Director
Key Sites Assessments
GPO Box 39
Sydney NSW 2001
NSW Department of Planning & Environment
State Significant Development.
Application No. **SSD 7693**

IMPACT ASSESSMENT REVIEW

The Astor Apartments.- 123- 125 Macquarie St.

Submission - Intercontinental Hotel- Alterations & Additions. Concept DA (Stage 1) that seeks approval for building envelopes to facilitate external alterations and additions and internal alterations and upgrade works to the Intercontinental Hotel, extending over part of Transport House.

SETBACK DIAGRAM | VIEW FROM NORTH-EAST

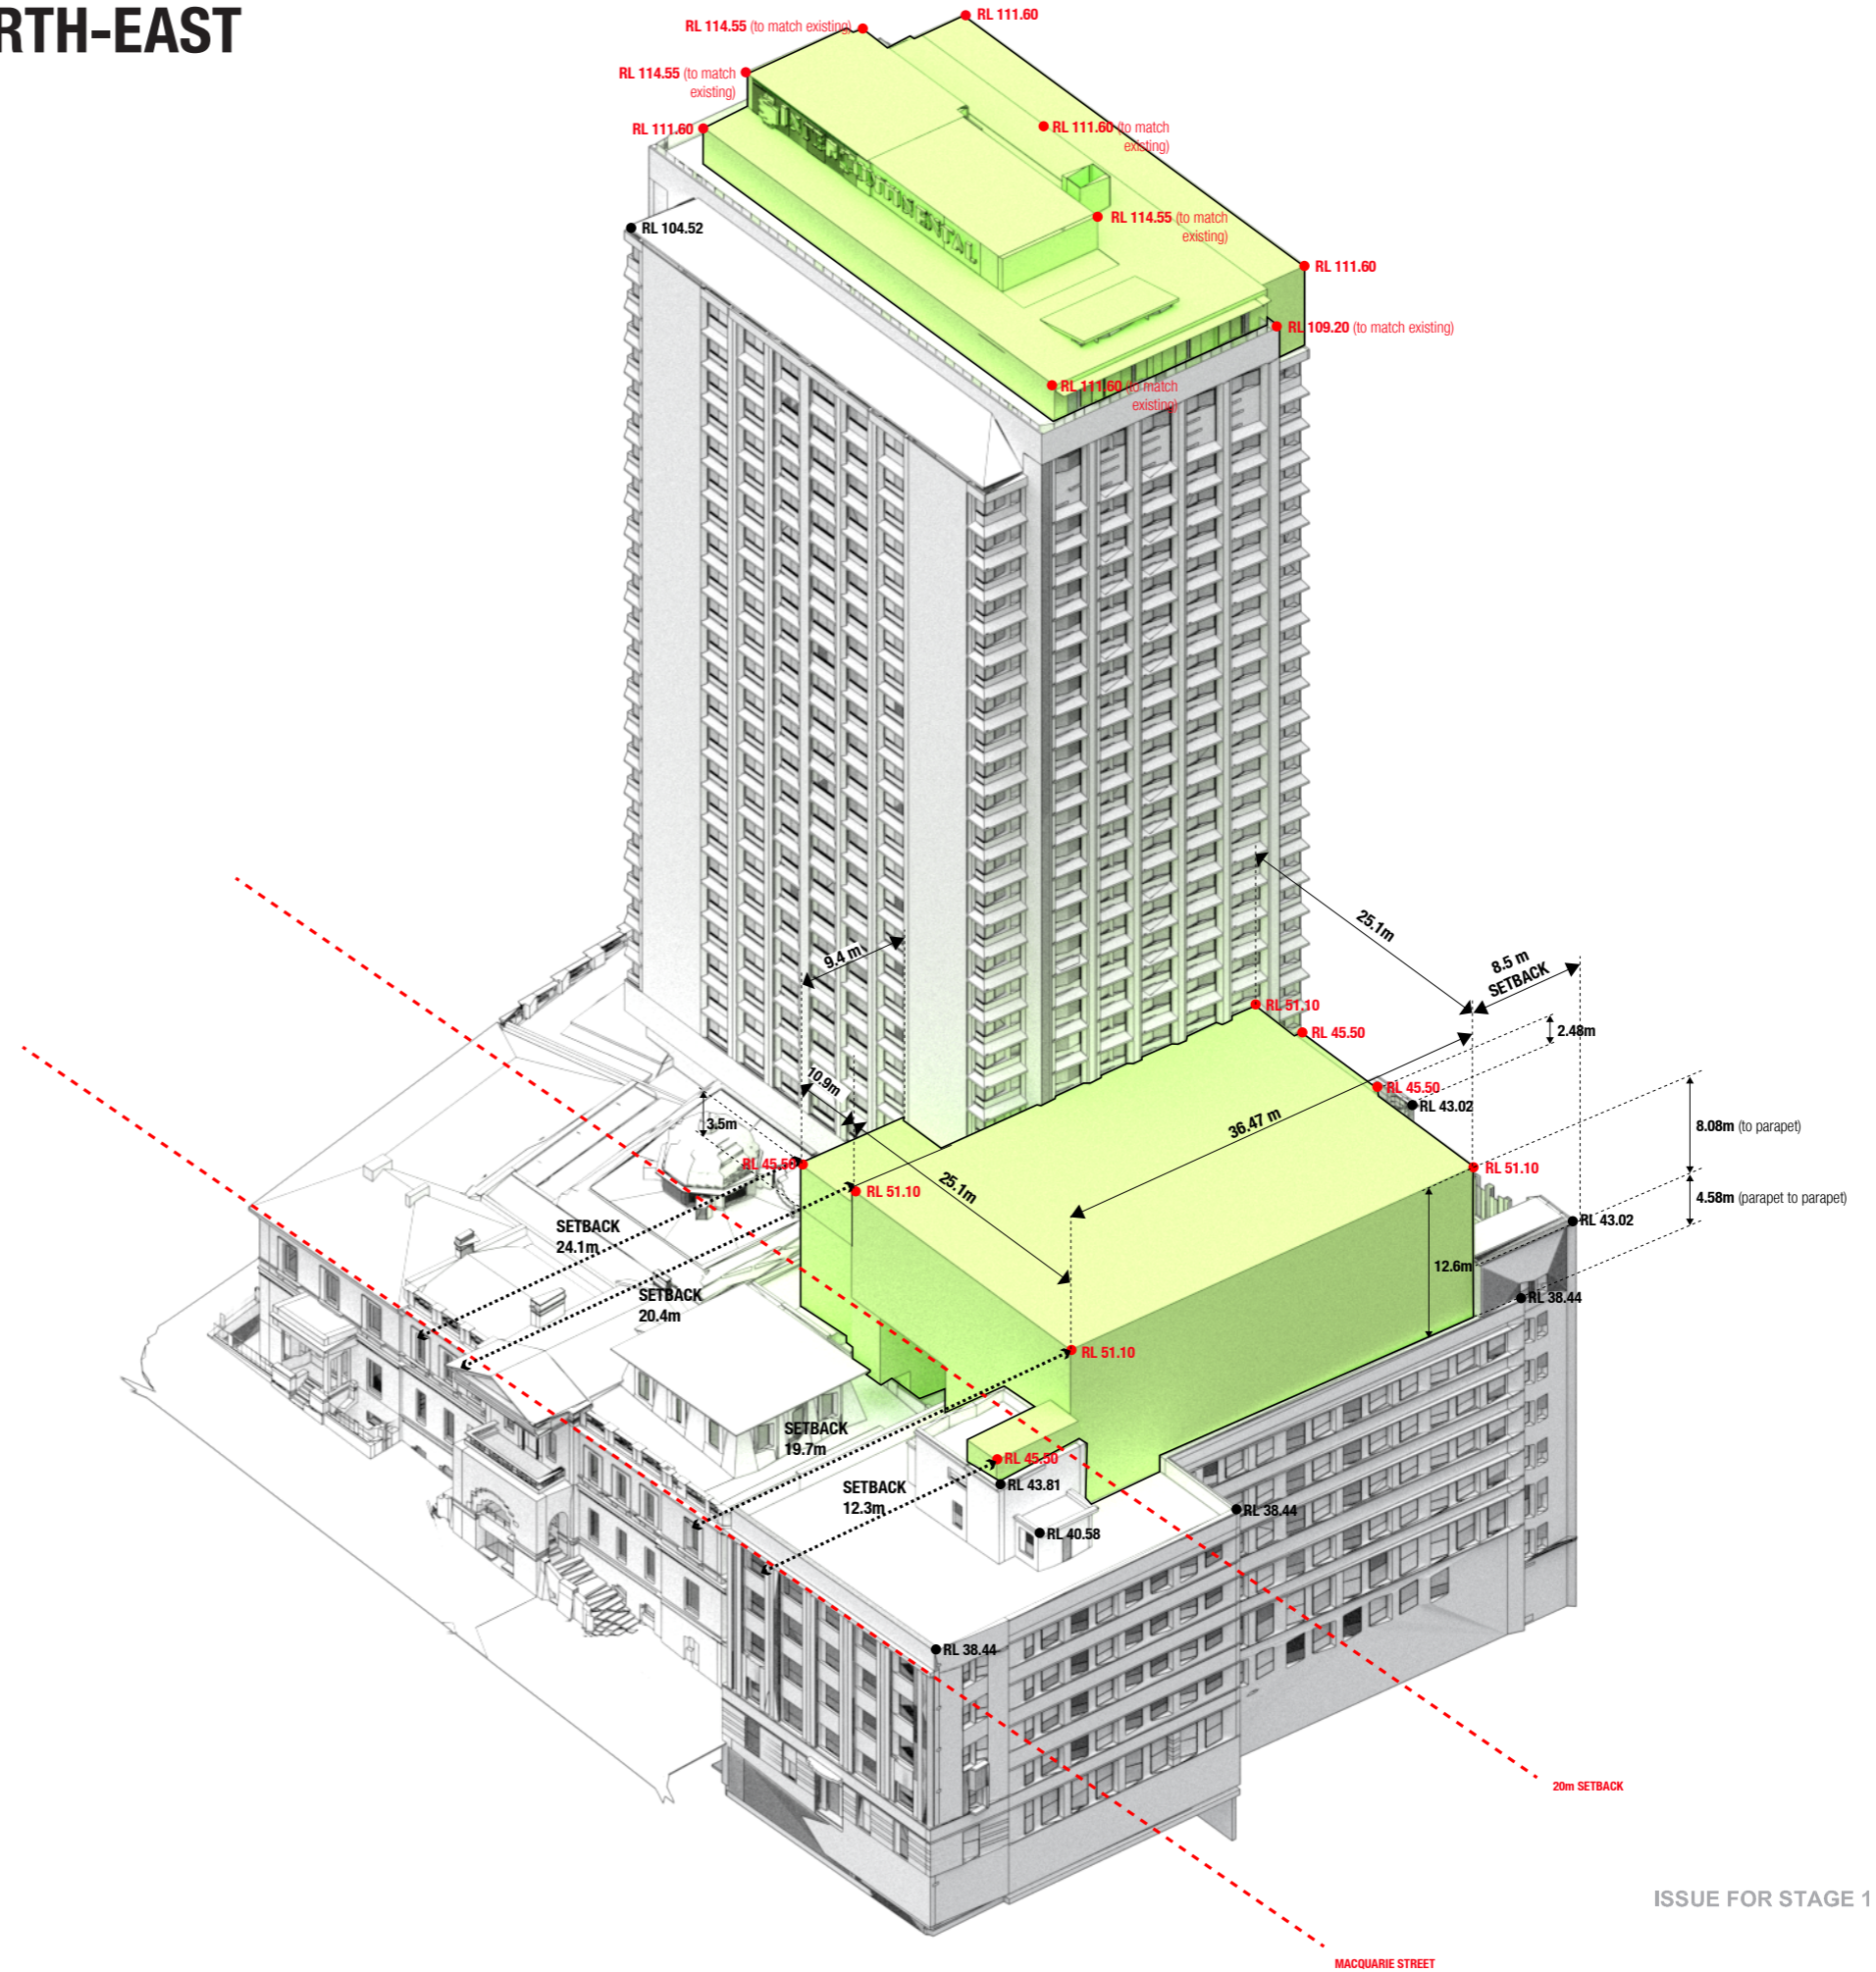
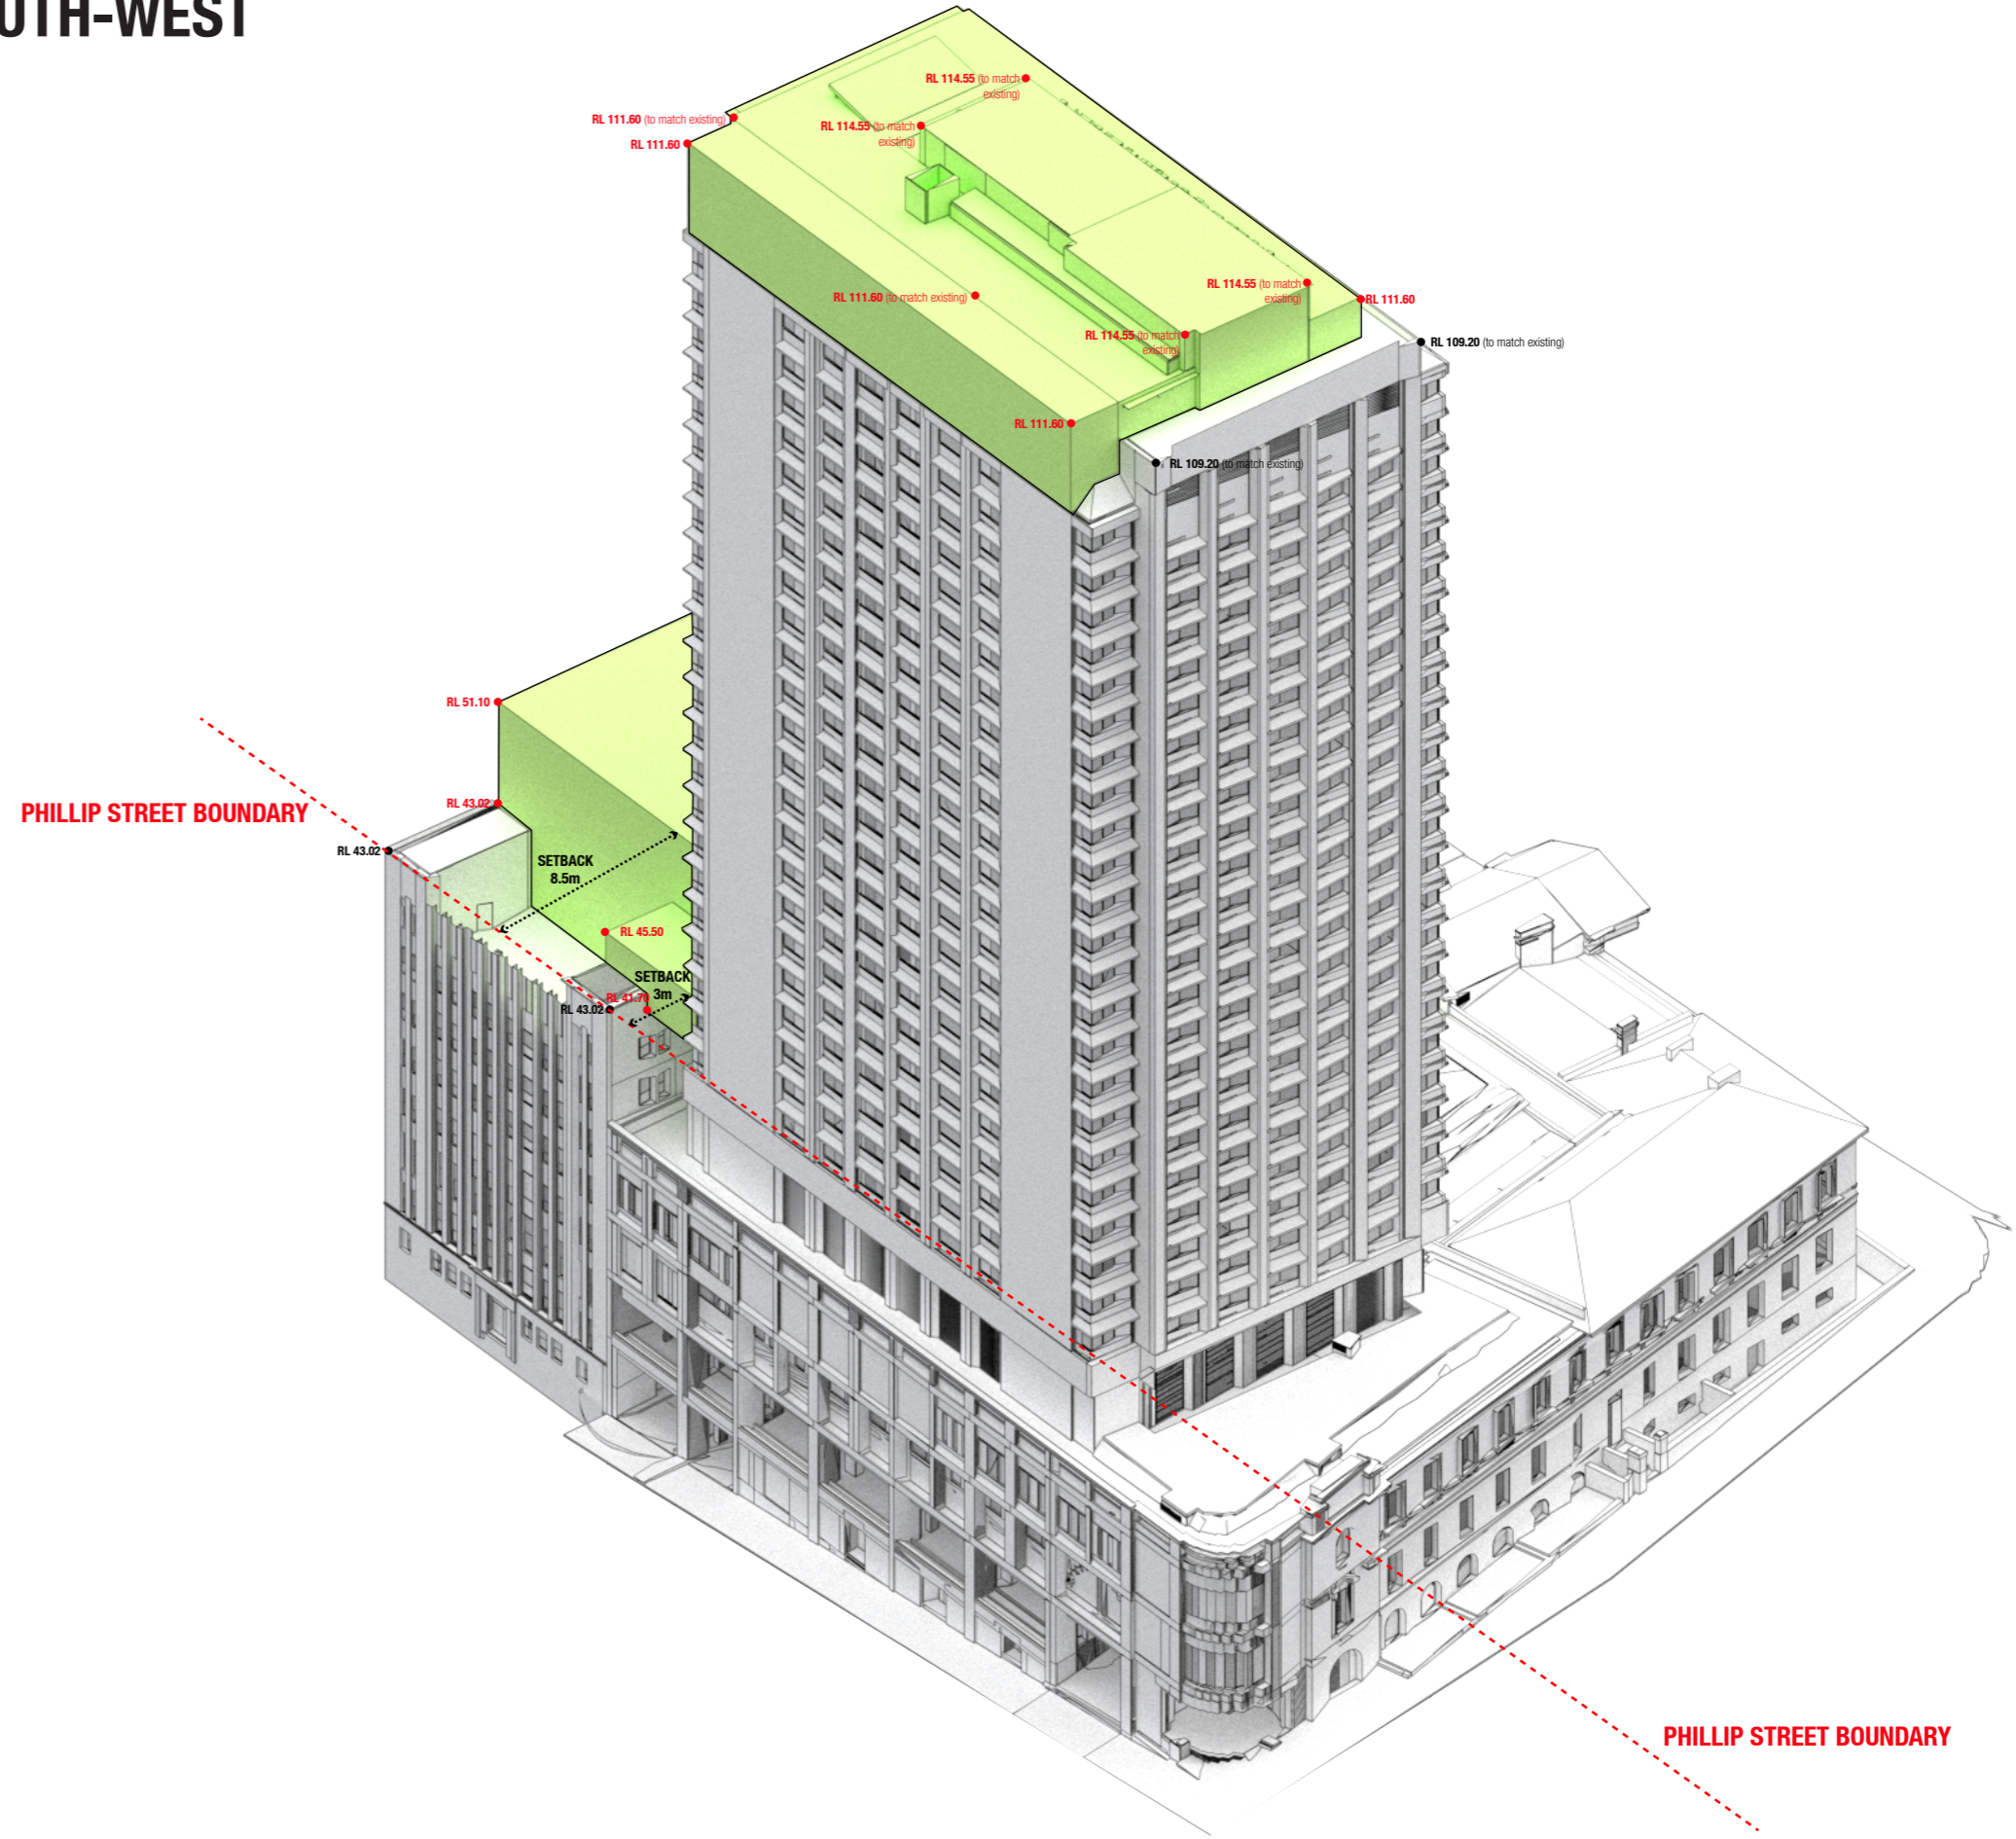
The proposed form of this new podium addition, over the existing low rise buildings to Macquarie Street, is not consistent with the current prevailing form of these buildings. (Attachment 4- Setback Diagram of the Proposed Envelope indicates this in relation to Macquarie St.) The proposal does not comply with the setback control indicated in the *Sydney Development Control Plan 2012* (DCP 2012) which is applicable in this location as identified in the *Macquarie Street Special Character Area* - (Area G.) It is understood that the proposal has sought to make adjustments to this setback, but our review is that the impact will be maintained and does not "enhance or complement the distinctive character ... with compatible development" as articulated as the objective of the control.

It is requested that the full extent of potential impact affecting the apartments on the north facing side of the Astor building, from floor level 12 to level 6, should be established. It is suggested that the additional bulk of the proposed low level podium for the 3-storey high ballroom will have significant impact on a number of these apartments, and that further reduction in height and form should be considered.
